CITY OF ALBUQUERQUE

June 24, 2014

**Re: FedEx Ground Drainage Report and Conceptual Grading Plan and Drainage Plan
Engineer's Stamp Date 5-19-14 (K09D026A)**

**OVERALL GRADING
AND DRAINAGE PLAN**

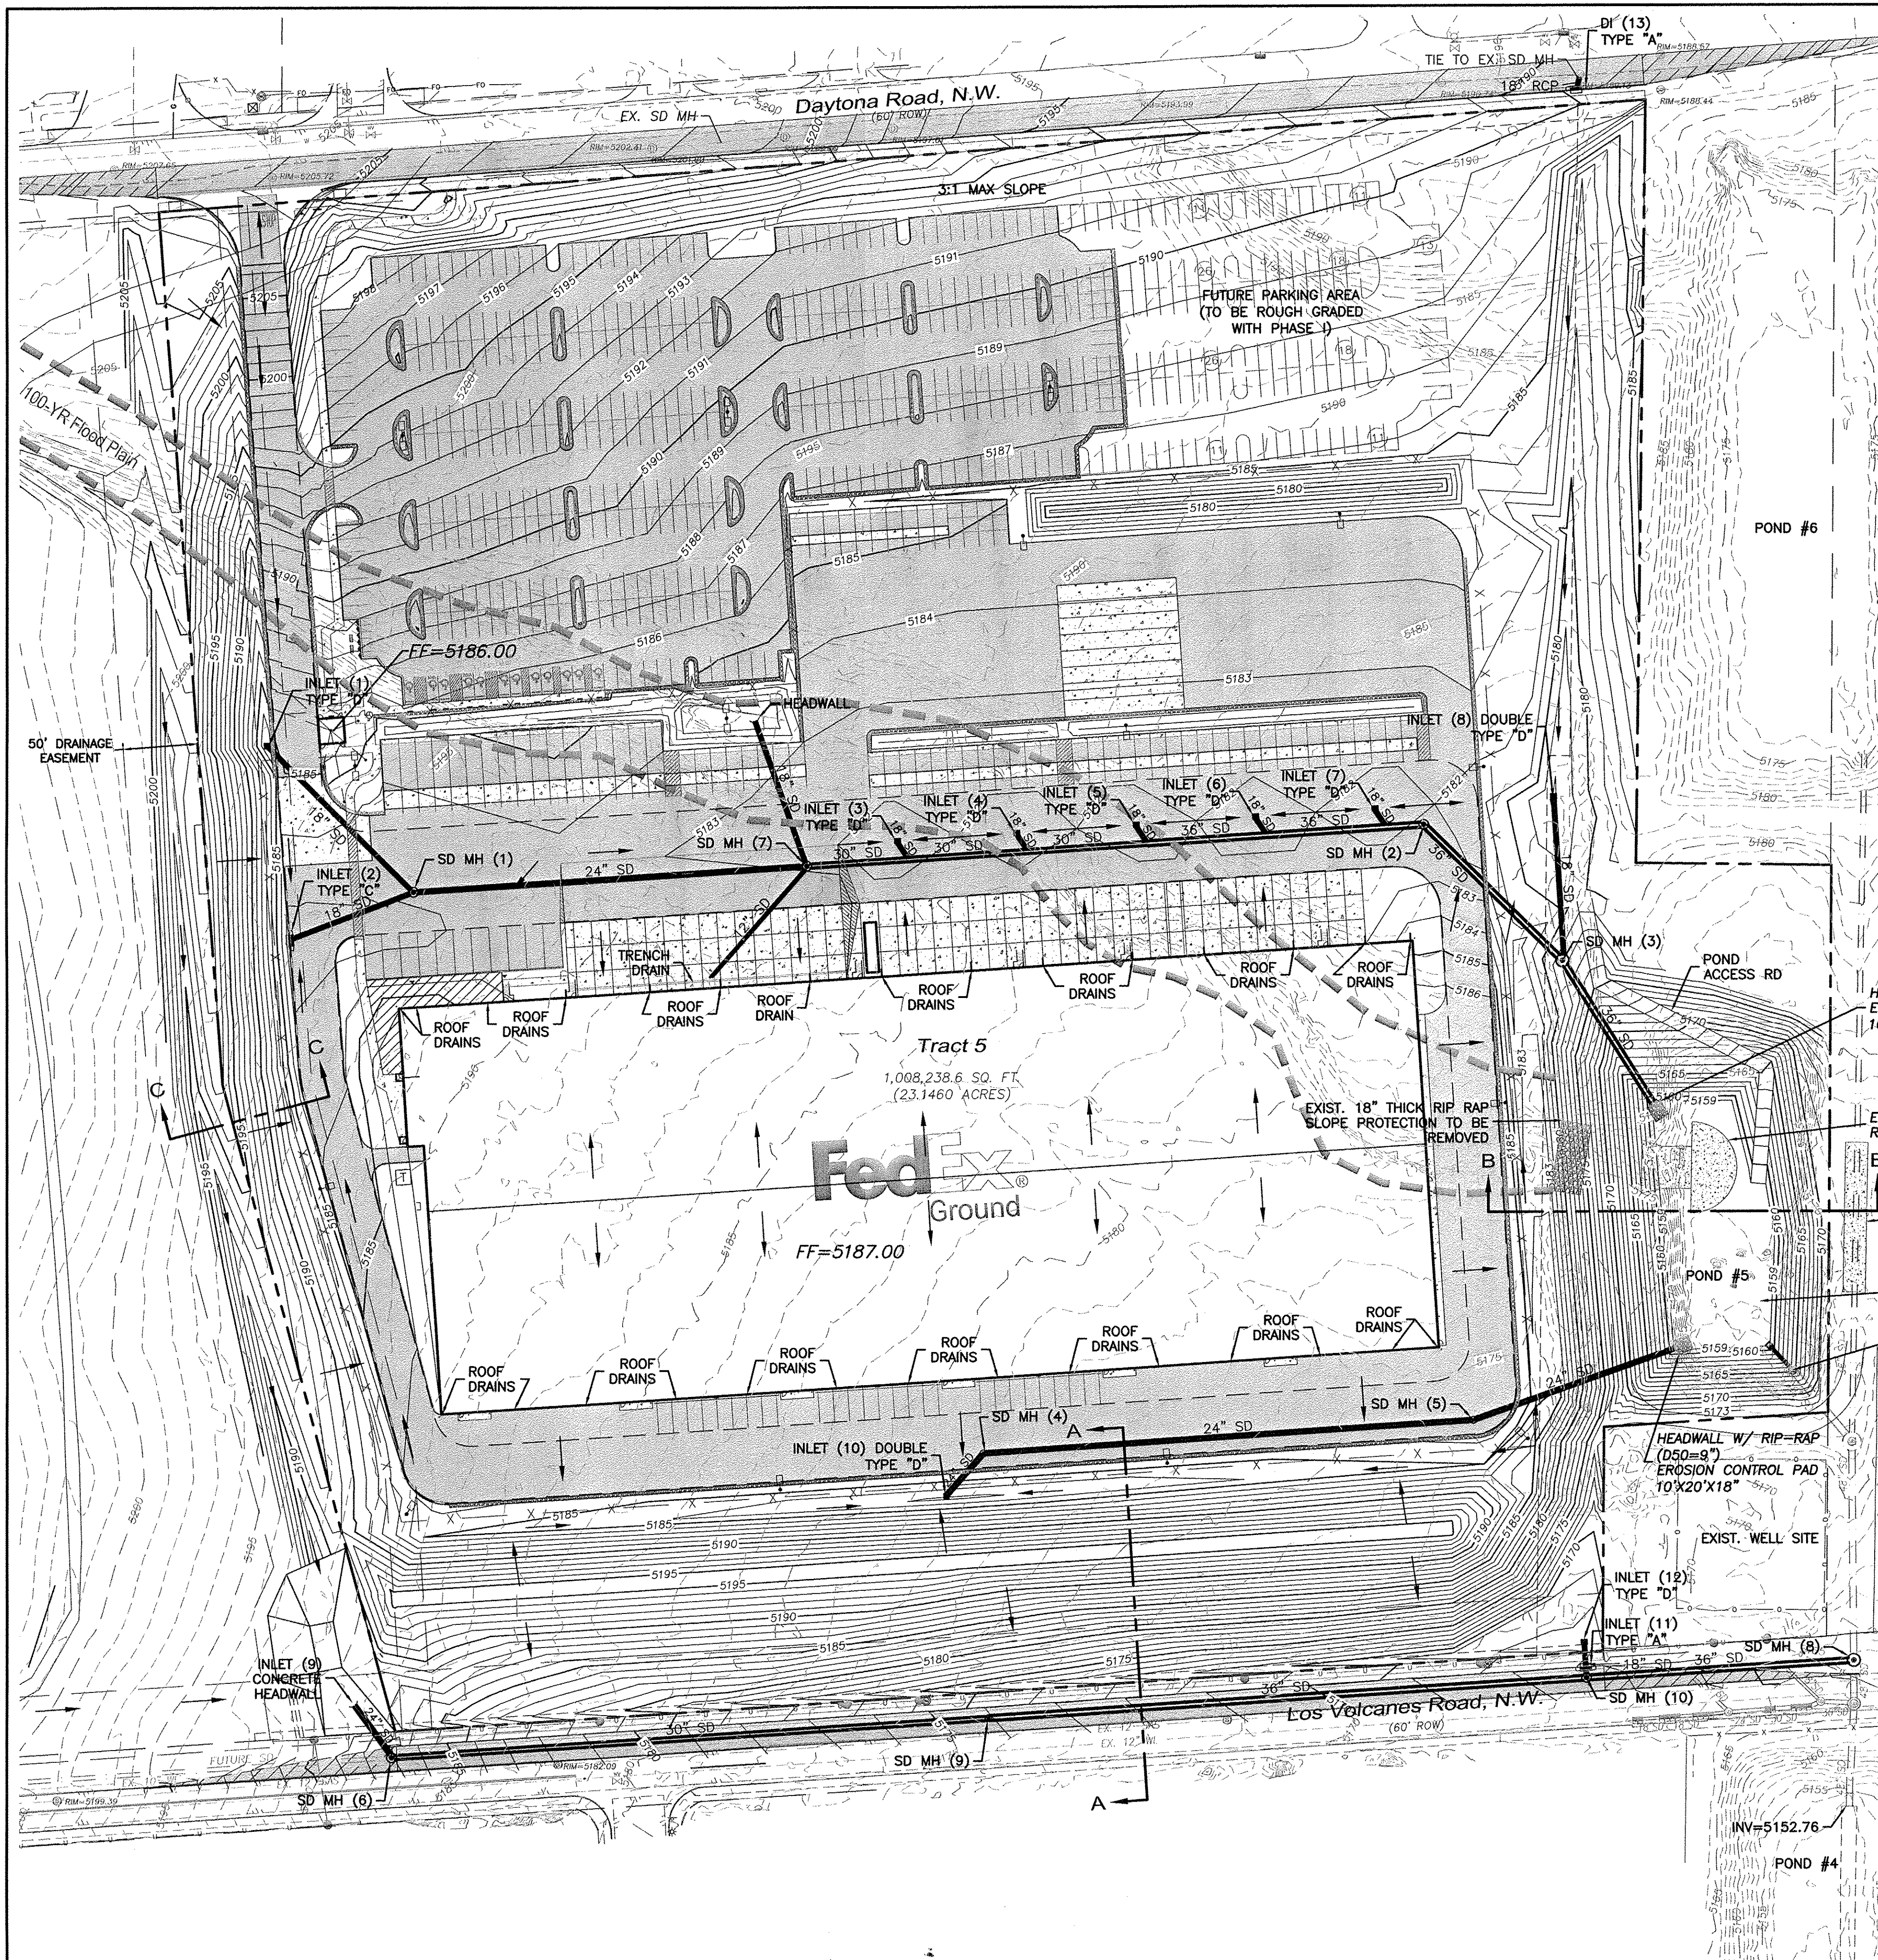
5. Provide calculations that show the required pond volume.
6. This report should size the storm drain in Los Volcanos Rd. How far west is the storm drain to be extended in Los volcanos Rd?

11. The outlet structure for Pond 5 is to be modified as the existing 8" holes easily plug. Hydrology would like a ported riser design. In addition, provide the as-builts for the outlet structure
12. The offsite area that historically drained to Pond 5 in the existing condition should be accommodated by inlet 9.

ENGINEER'S SEAL RONALD R. BOHANNAN P.E. #7868	FEDEX GROUND ALBUQUERQUE, NM		DRAWN BY DY
	INTERIM GRADING AND DRAINAGE PLAN		DATE 7-3-14
	TIERRA WEST, LLC 5571 MIDWAY PARK PLACE NE ALBUQUERQUE, NM 87109 (505) 858-3100 www.tierrawestllc.com		2013075-GRE-INTERIM
	SHEET # GR-4		JOB # 2013075

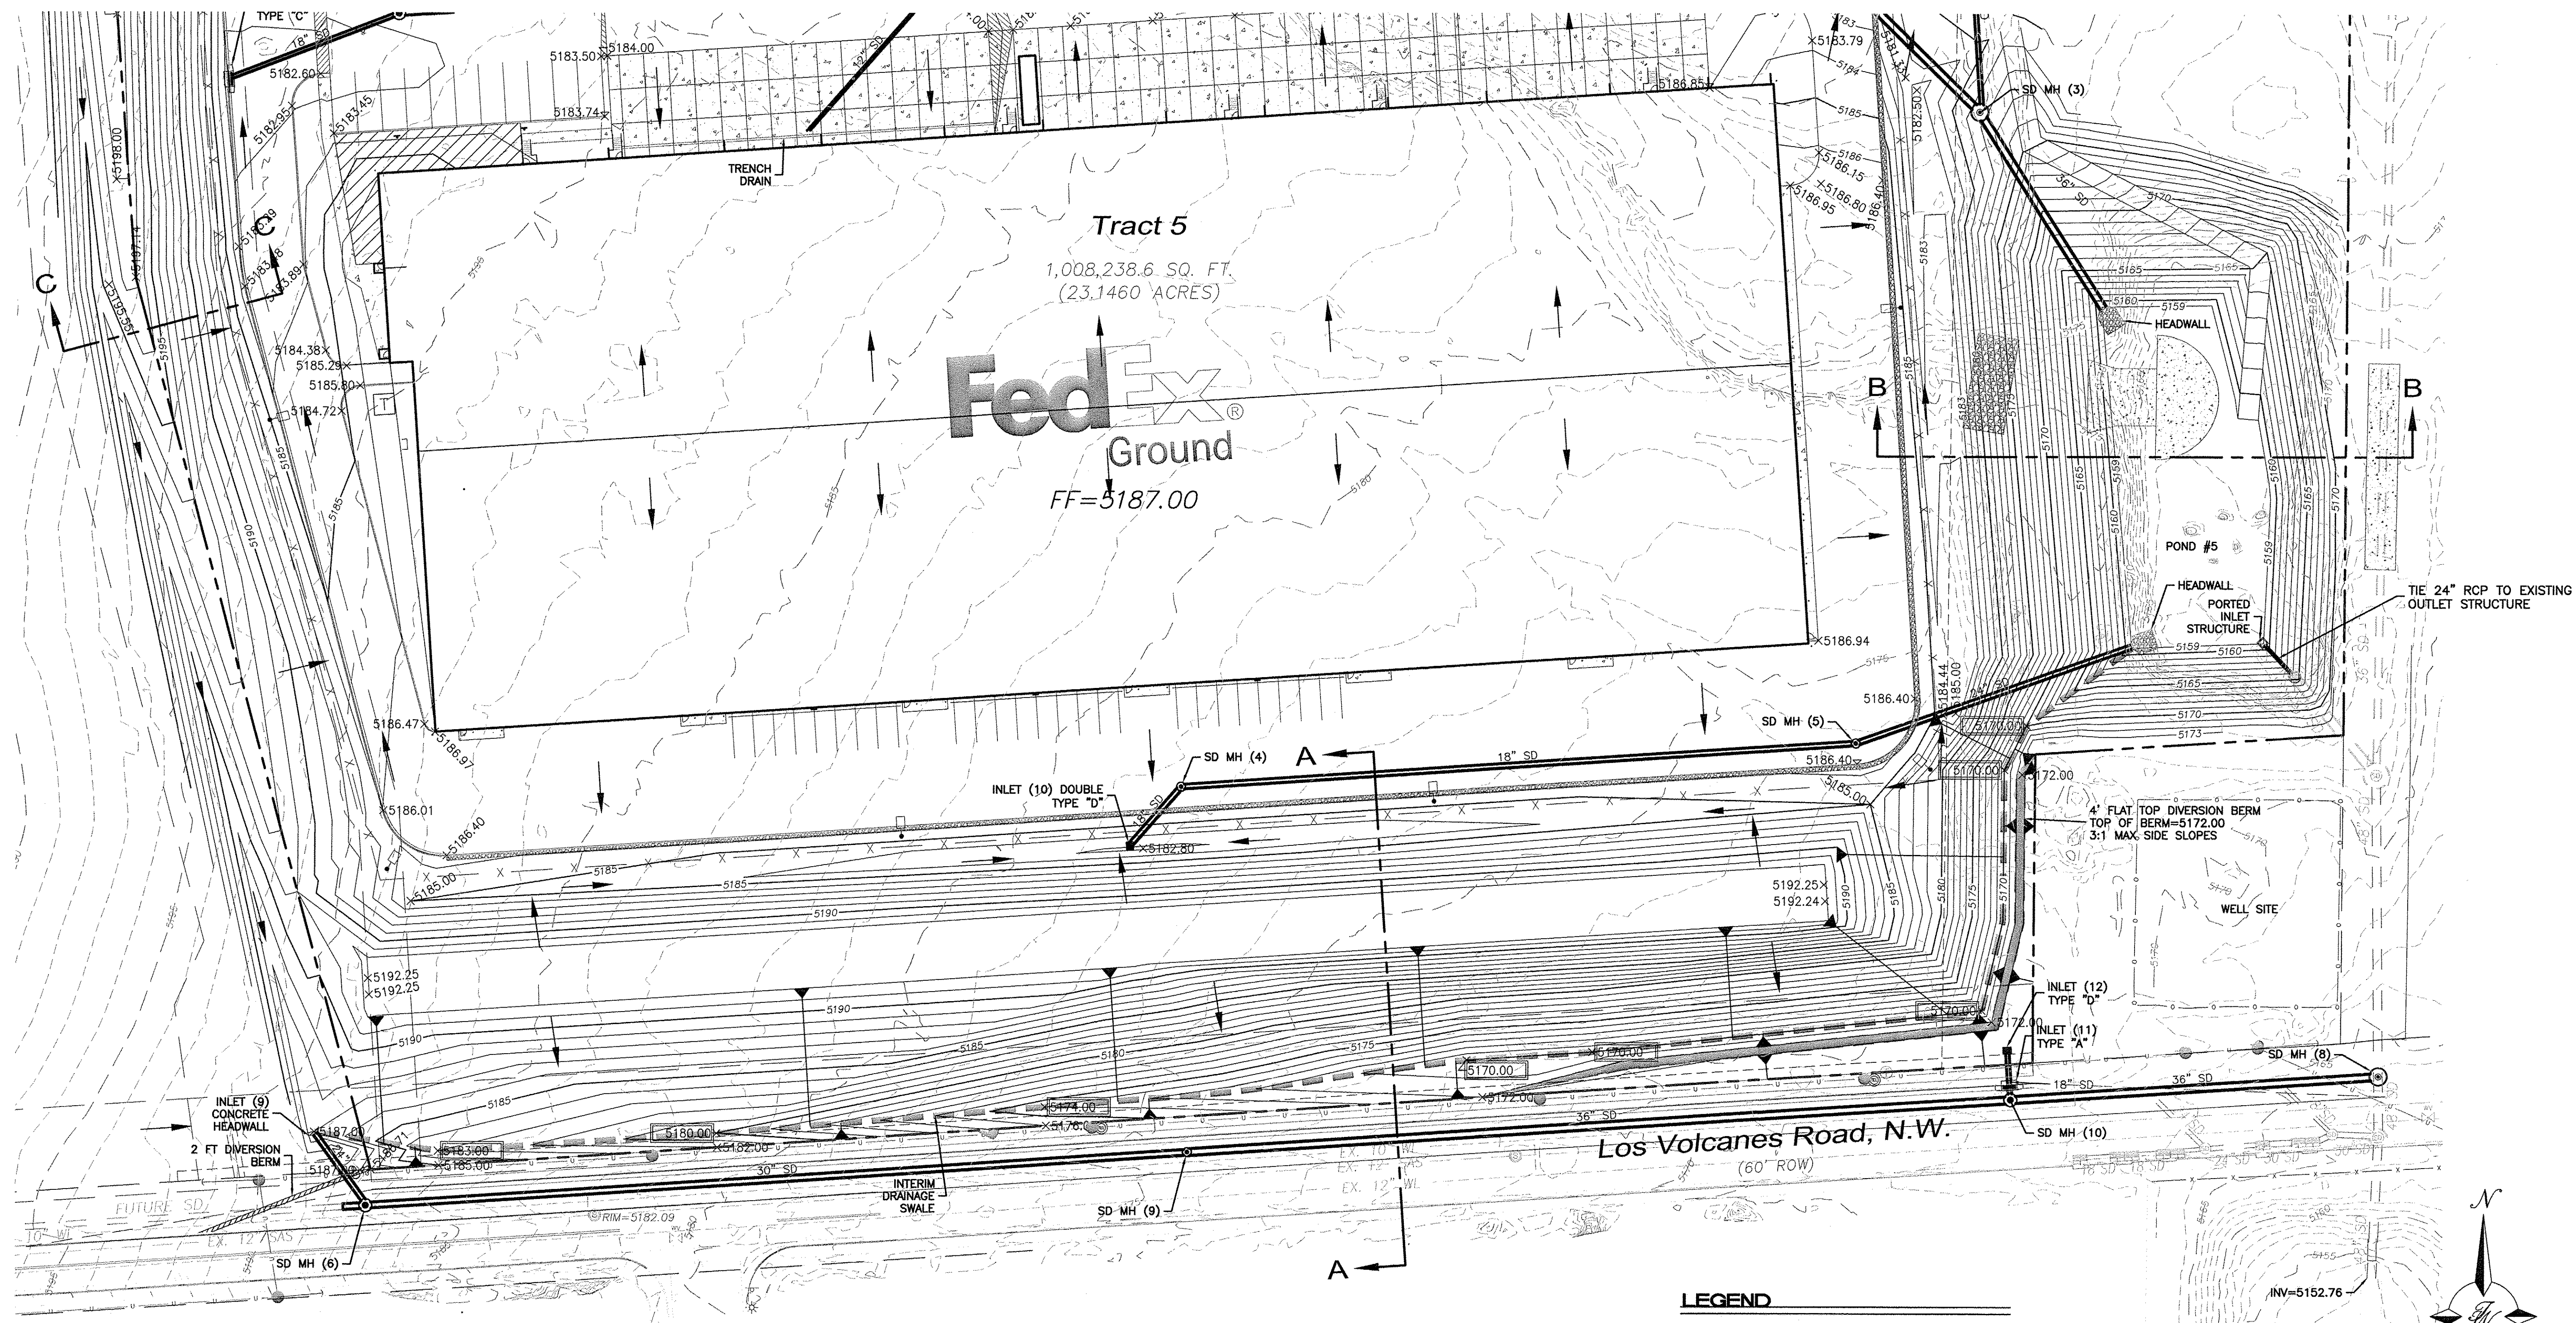
7. Why is there an interim Post Developed basin Table? Why not just existing and developed?
8. The easement for floodplain and drainage works is to be vacated.
